24 March 2021

School Infrastructure NSW (SINSW) on behalf of the Department of Education (DoE) is seeking to modify Conditions A2, C22(c), D5 and D33(c) of the development consent for the Picton High School Redevelopment (SSD 8640) pursuant to section 4.55(1A) of the *Environmental Planning and Assessment Act 1979*.

VISION | LANDSCAPE MASTERPLAN

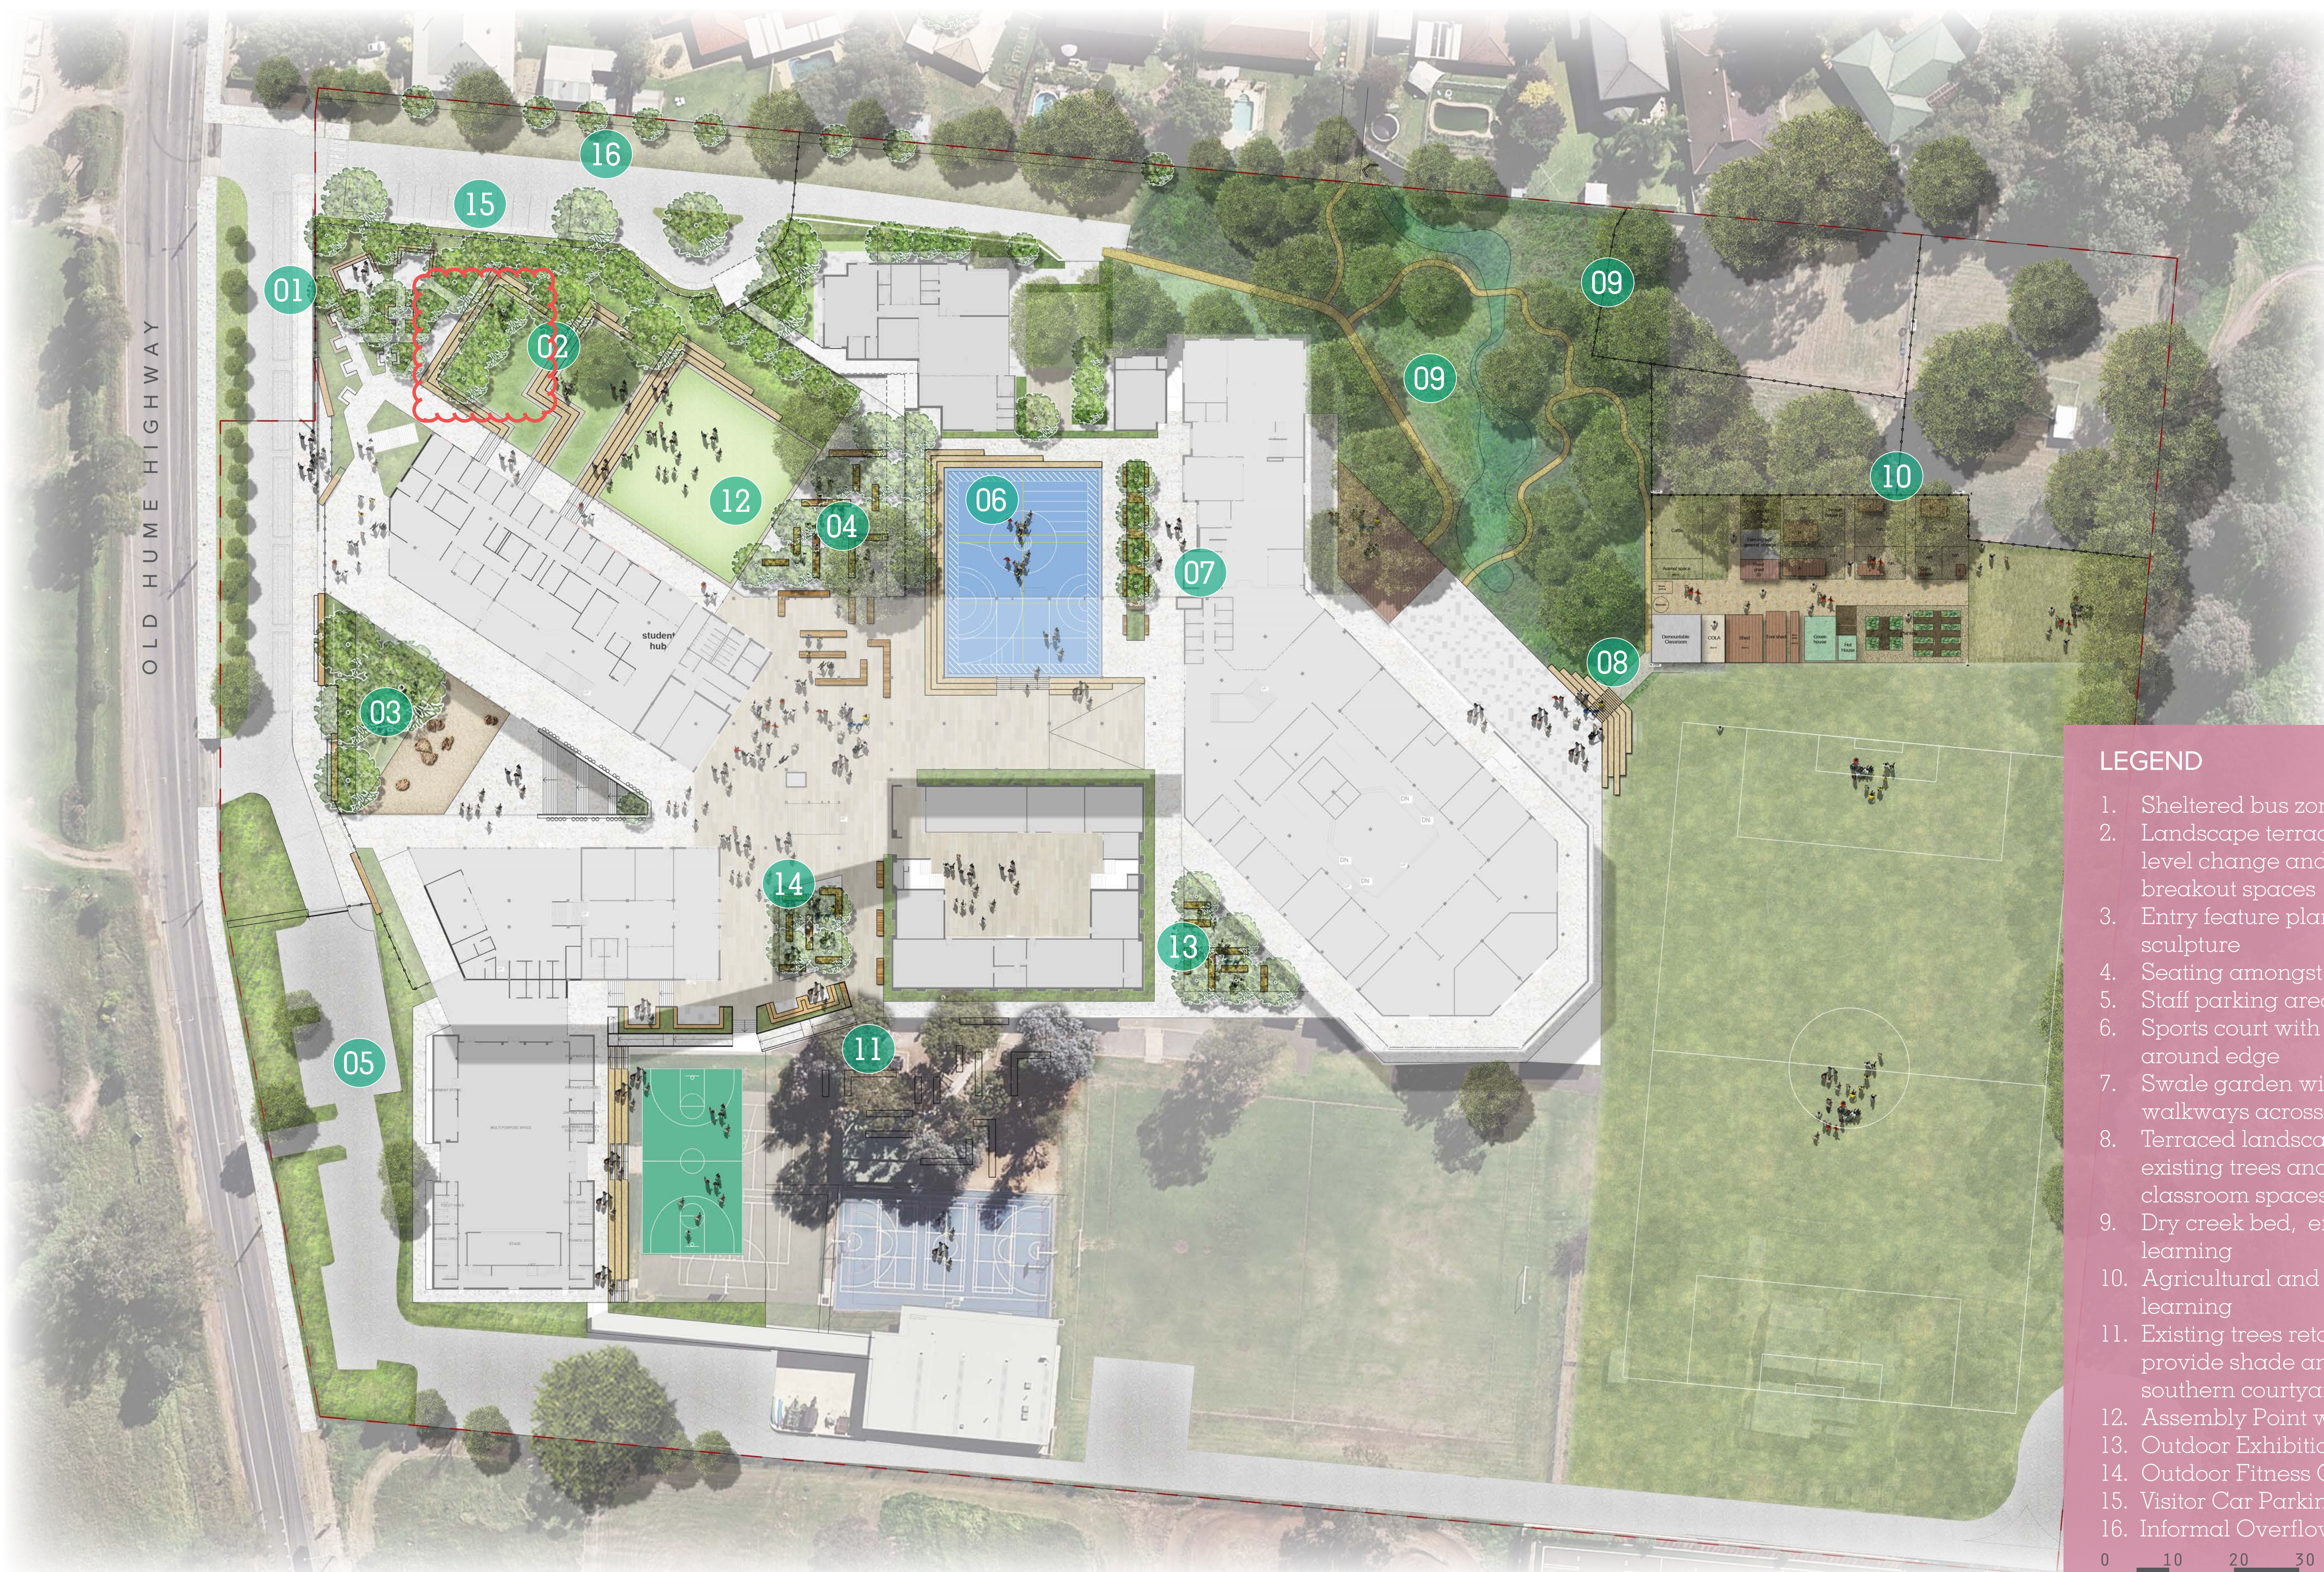
- (i) update the landscape plans identified in Conditions A2, C22(c) and D36 to reflect the removal of the Red River Gum tree (*Eucalyptus camaldulensis*) which was located adjacent to Building B and the proposed replacement planting of three (3) Forest Red Gums (*Eucalyptus tereticornis*) in this location; and
- (ii) include a new condition which requires pre-construction dilapidation reporting to be undertaken prior to the commencement of certain works adjacent to the northern boundary of the site associated with the construction of the car park.

Proposed Revisions to Conditions of Consent	Discussion / Justification
D36. Prior to occupation of the building, the Applicant must prepare a Landscape Management Plan to manage the revegetation and landscaping works on-site, to the satisfaction of the Planning Secretary. The plan must: (a) Include revised landscape plan as per condition B4 to include planting in accordance with the approved Softscape Tree Size Specification & Formal Softscape Areas (Issue B C) prepared by Arcadia Landscape Architecture dated March 2019 November 2020 and at least 14 additional canopy trees; (b) detail the species to be planted on-site; (c) include details of the area surrounding the education trail is to be rehabilitated with local native plants; (d) include details that the native trees to be removed from the site are to be salvaged, including tree hollows and tree trunks (greater than 25cm in diameter and 3m in length) and used to enhance habitat at the site; (e) include details of the installation of artificial nest boxes which are suitable to native fauna; (f) detail that the seeds from native plants to be removed is collected and used in the landscape area; (g) provide an ongoing weed control and maintenance program to maintain the existing and new remnant native vegetation; (h) describe the monitoring and maintenance measures to manage revegetation and landscaping works; and (i) comply with the principles of Appendix 5 of <i>Planning for Bush Fire Protection 2006</i>.	SINSW seeks approval to amend Condition D36 to update the approved Tree Size Specification and Formal Softscape Areas to reflect the removal of the subject tree and the planting of three (3) replacement trees in its previous location. Amended landscape drawings are included at Attachment 4.

Dwg No.	Rev	Name of Plan	Date
	B E	Vision Landscape Masterplan	February 2018 December 2020
	C	Cultural + Heritage Items	May 2018
	C	Landscape Sections	May 2018
	C	Landscape Sections – Section A-A	May 2018
	C	Landscape Sections – Section B-B	May 2018
	C	Landscape Sections – Section C-C	May 2018
	B	Materials Pavement	February 2018
	B	Materials Pavement	February 2018
	B E	Detail Entry Forecourt	February 2018 December 2020
	B E	Detail Terraced Lawns	February 2018 December 2020
	B	Materials Terraced Lawns	February 2018
	B	Detail Social Hub	February 2018
	B	Materials Social Hub	February 2018
	B	Detail Education Trail	February 2018
	B	Materials Education Trail	February 2018
